173 Holm Ave. Permit Application 2016-02895 - Plan Review Questions/Comments Inbox x

**Subject:** 173 Holm Ave. Permit Application 2016-02895 - Plan Review Questions/Comments

173 Holm Ave

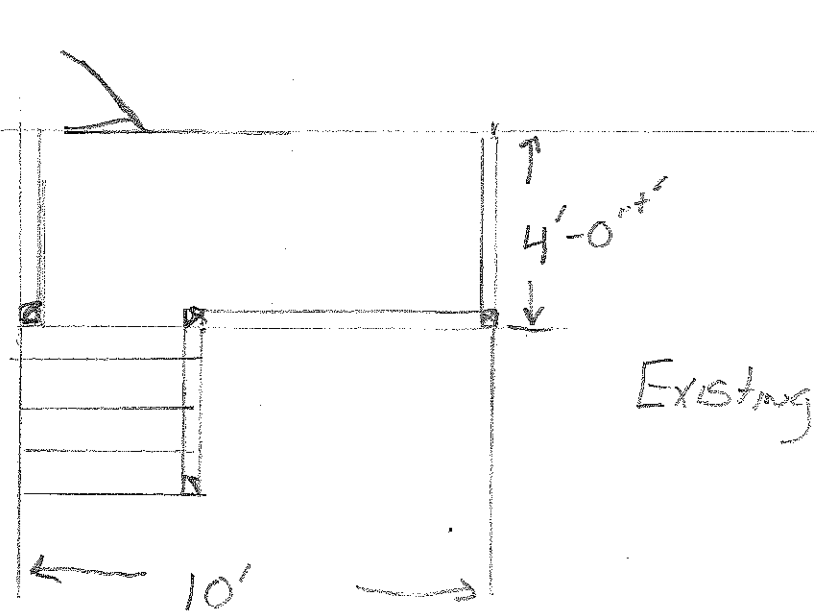
I have reviewed the submitted drawings and have the following questions:

1. Do you intend to reuse (or replace) the existing guards? No we plan to keep guard rails
2. Please describe mechanical fasteners to be used at the base and top of each new 4x4 post. Going to use simpson HL 55 g
3. Please describe the size/spacing of collar ties. 16" oc
